CITY OF ALBUQUERQUE

August 10, 2017

**Re: APS Highland High School Gymnasium Upgrade
Erosion and Sediment Control Plan
Engineer's Stamp Date 8-3-17 (K17E021)**

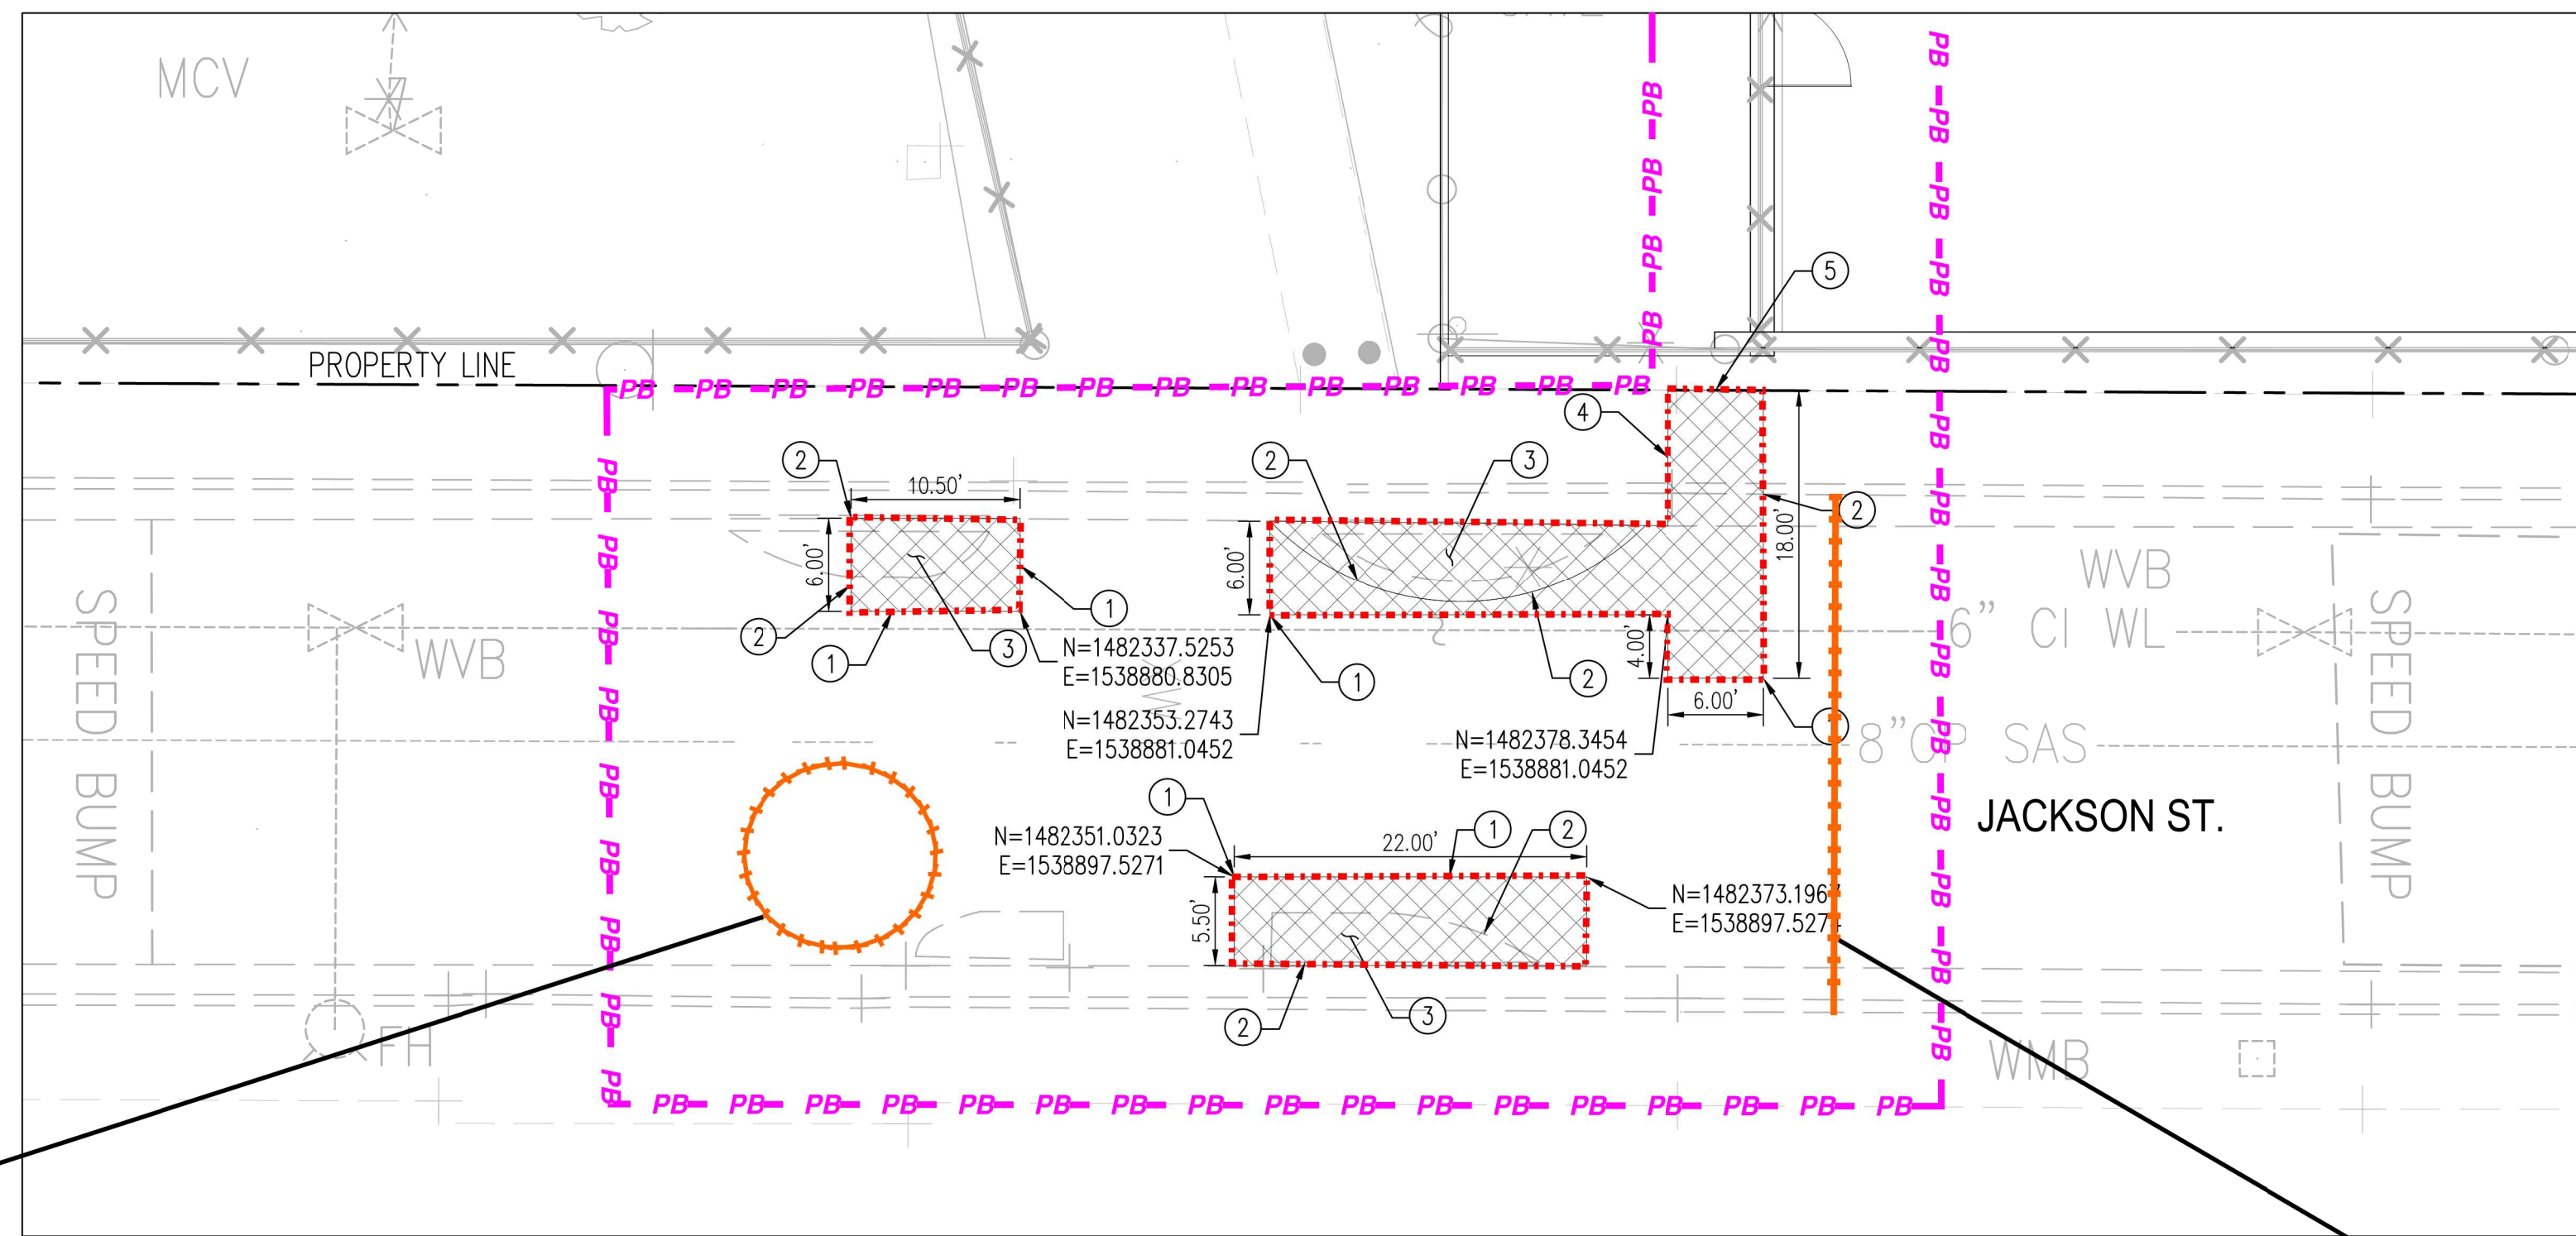
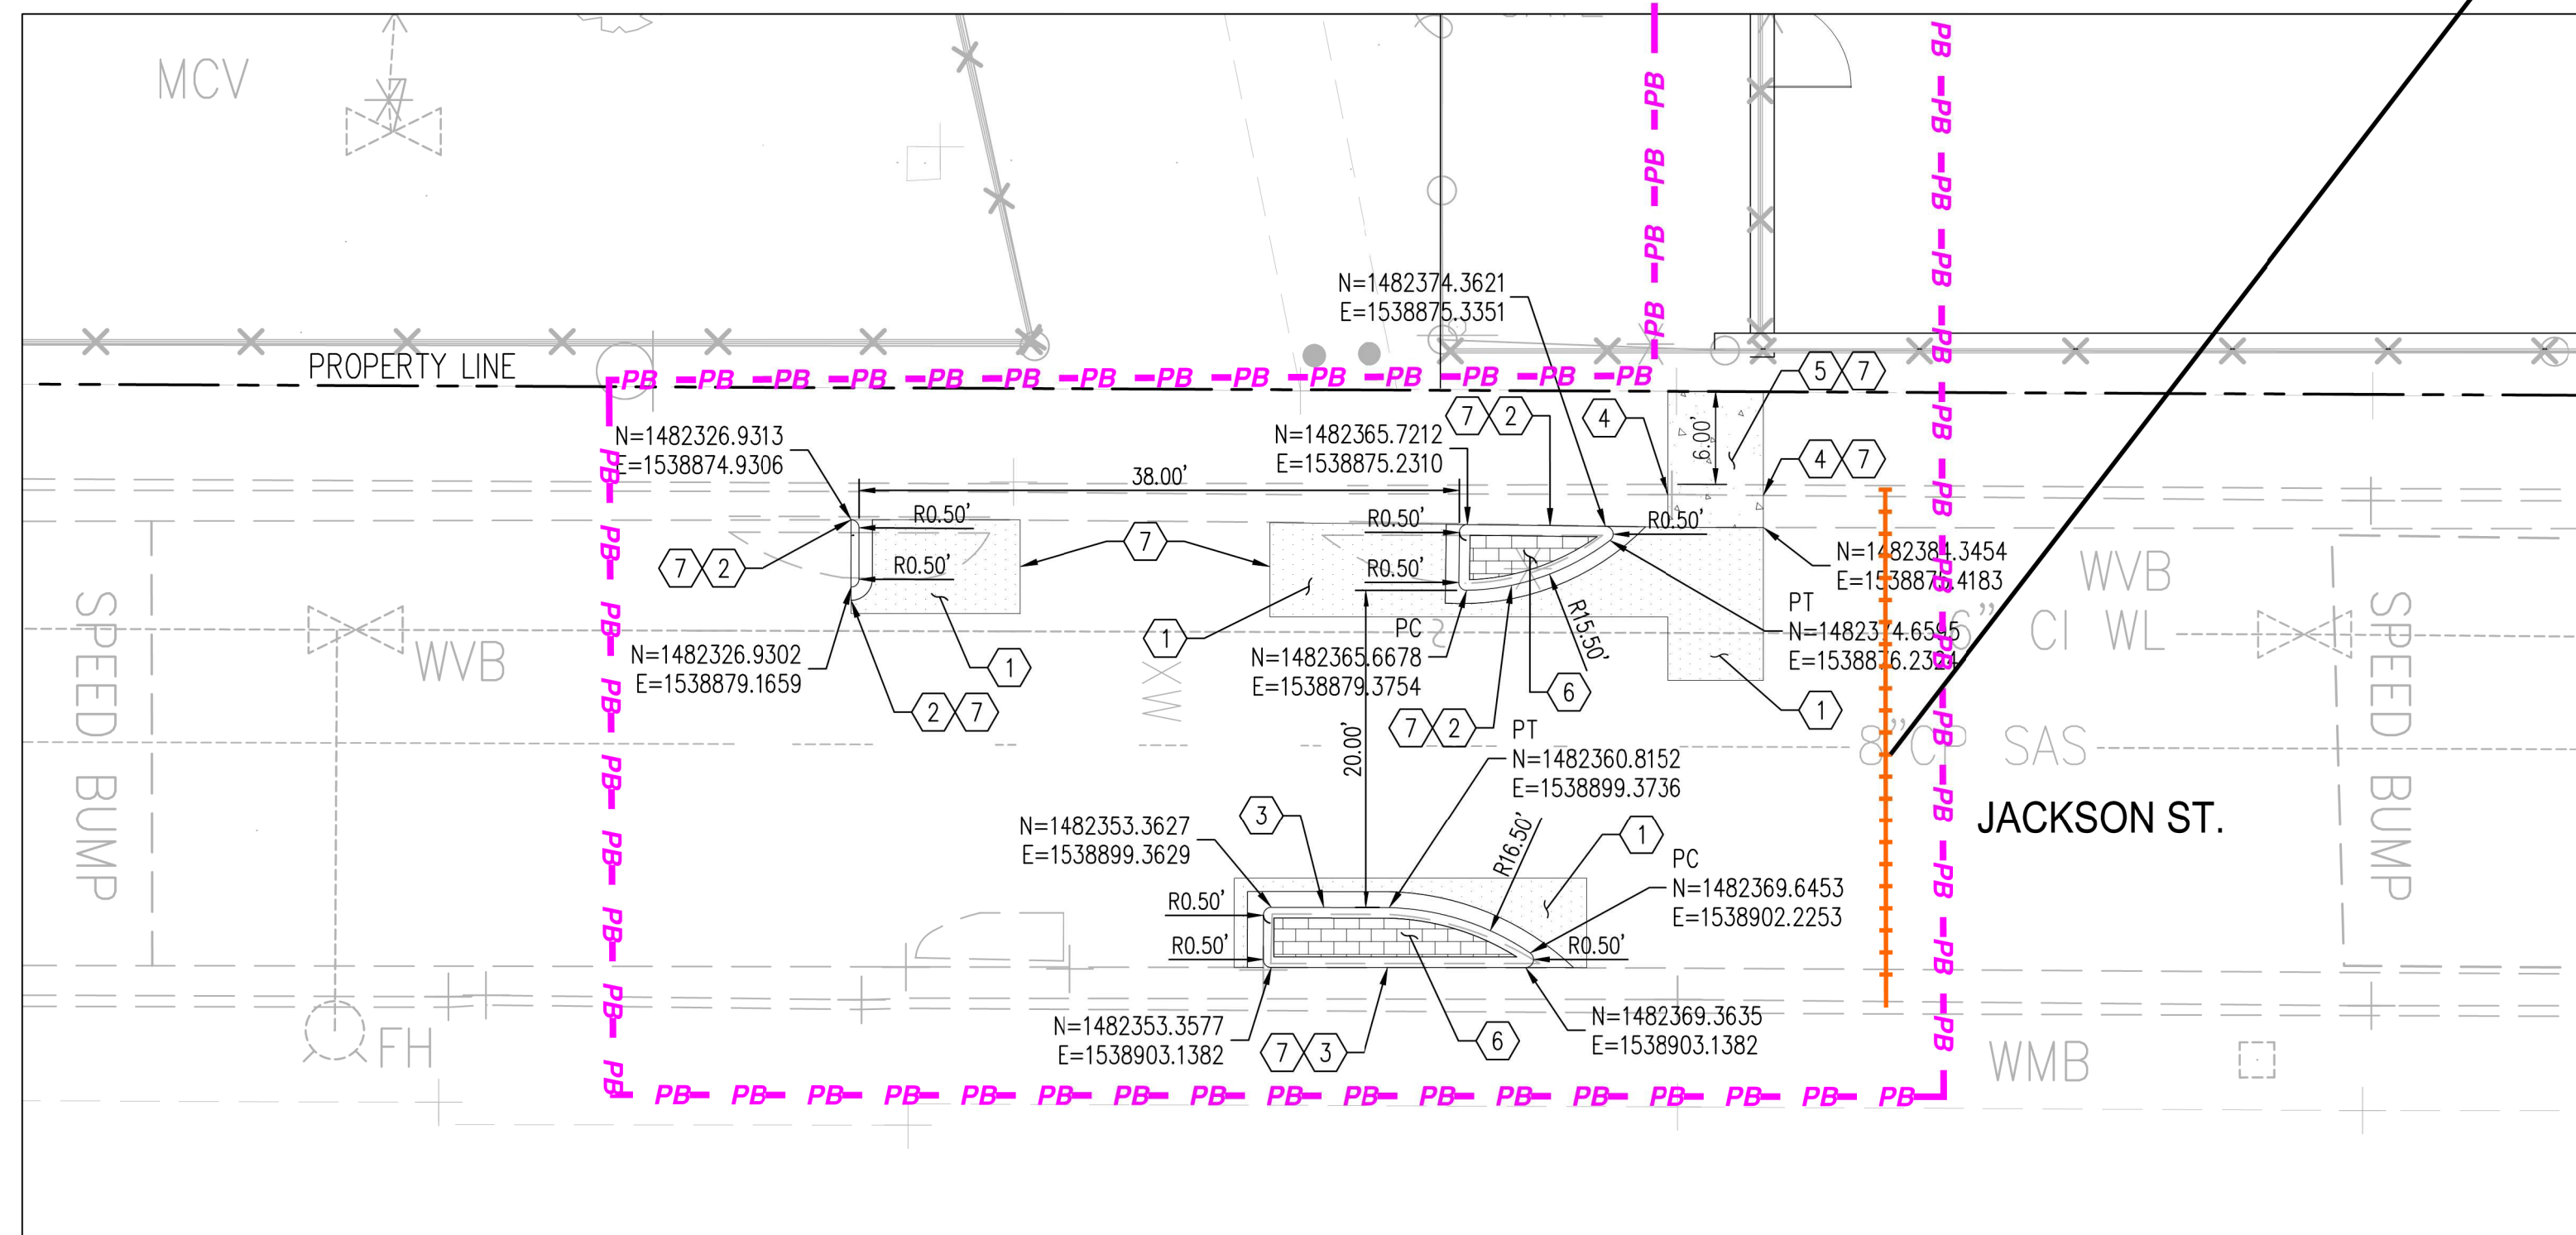
1. Provide BMPs for the proposed utility and street work in Jackson St.
